18-12 GENERAL RESPONSE TO EIS

Concern:

Figure 2: West-east modelled cross section. Source: Adapted from Figure 51 from (Jacobs (Australia), 2020, pp. 5-143)

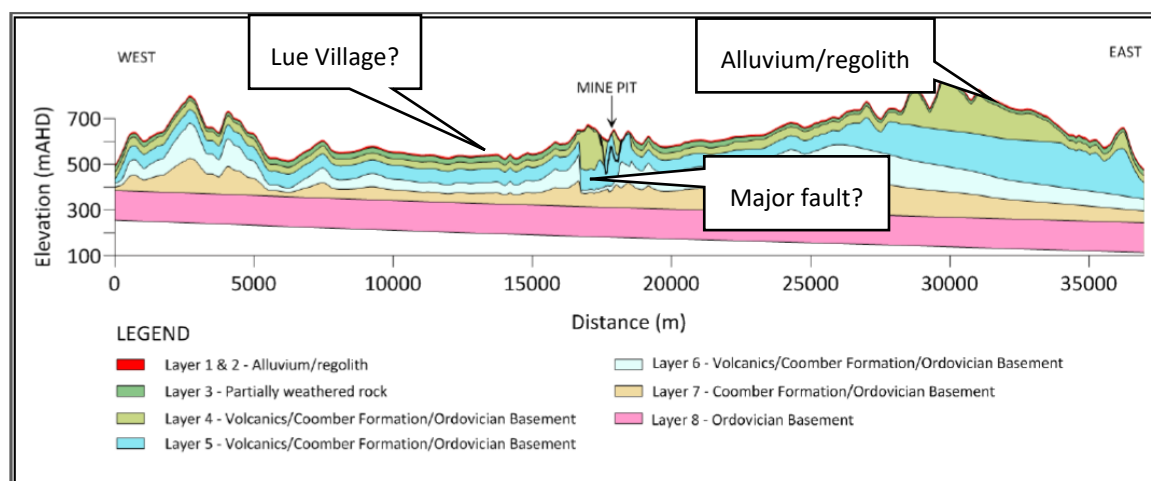
- Misrepresented groundwater quality at Lue Village
 - A lack of hydrostratigraphic interpretation between the site and Lue Village, including outcrop of the Coomber Formation

Figure 1: WRE plan showing 5 m elevation contours. Source – adapted from DSK-1002 (Advisian, 2020, p. 35)

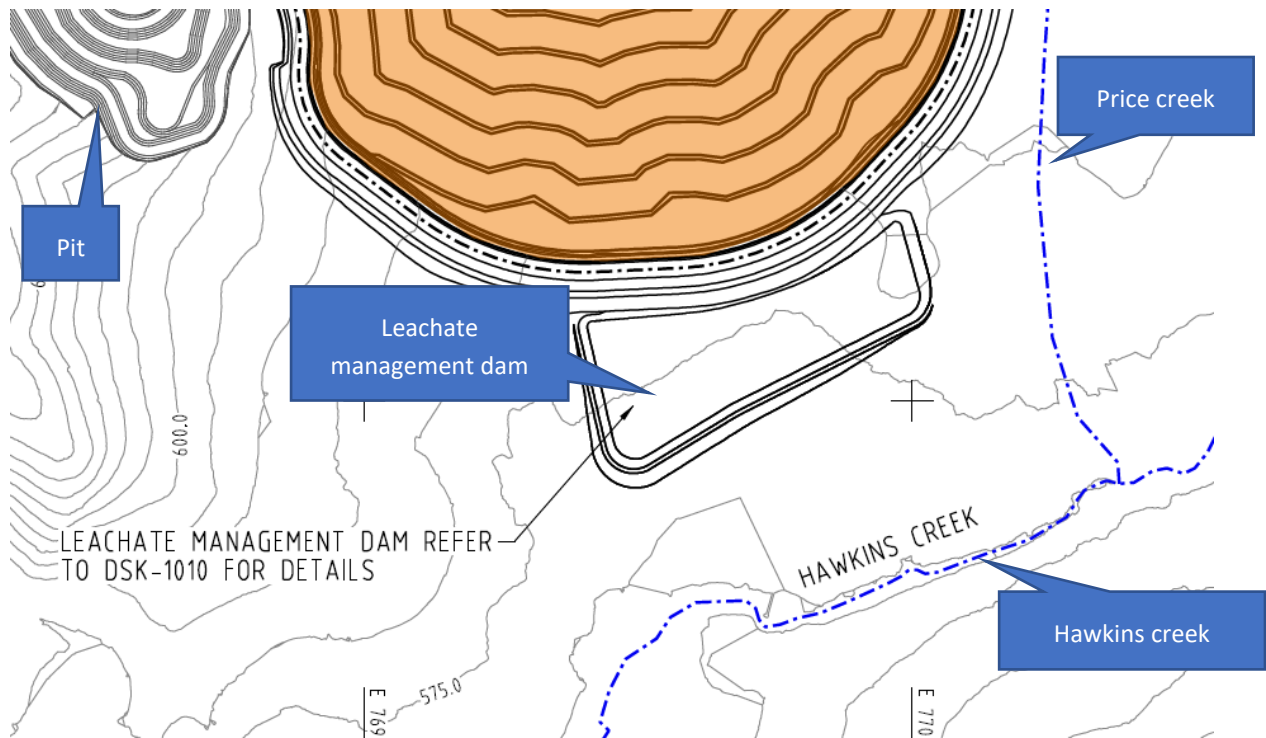
- The method of intercepting contaminated groundwater leaching from the TSF is not defined. The level of confidence in the proposed approach to capture contaminated groundwater before it travels 40 m beyond the mine site boundary is low.

Figure 3: Mapped faults in the area of the planned WRE and leachate management dam. Source – adapted from Figure 11 of (Jacobs (Australia), 2020, pp. 5-57)

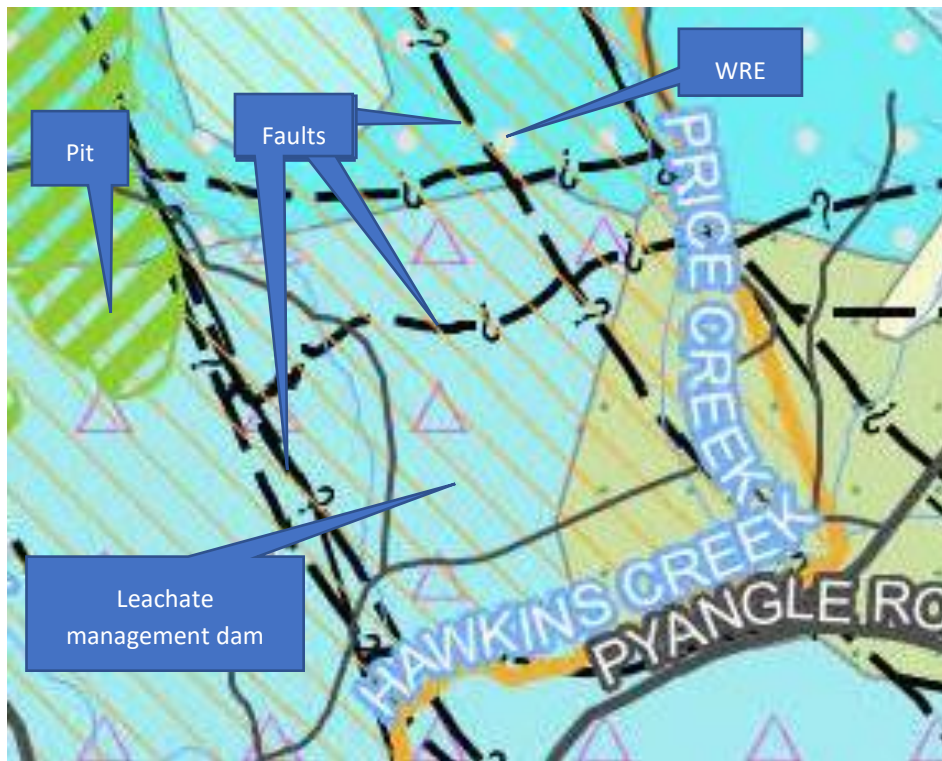
- A lack of consideration of the impact of faults, especially around the TSF and leachate management dam
 - The provenance of hydraulic conductivity testing does not extend across the faults, with the current uncertainty range. Considering the uncertainty, the proposed range of between 50-300 years to fill the pit is relatively narrow.
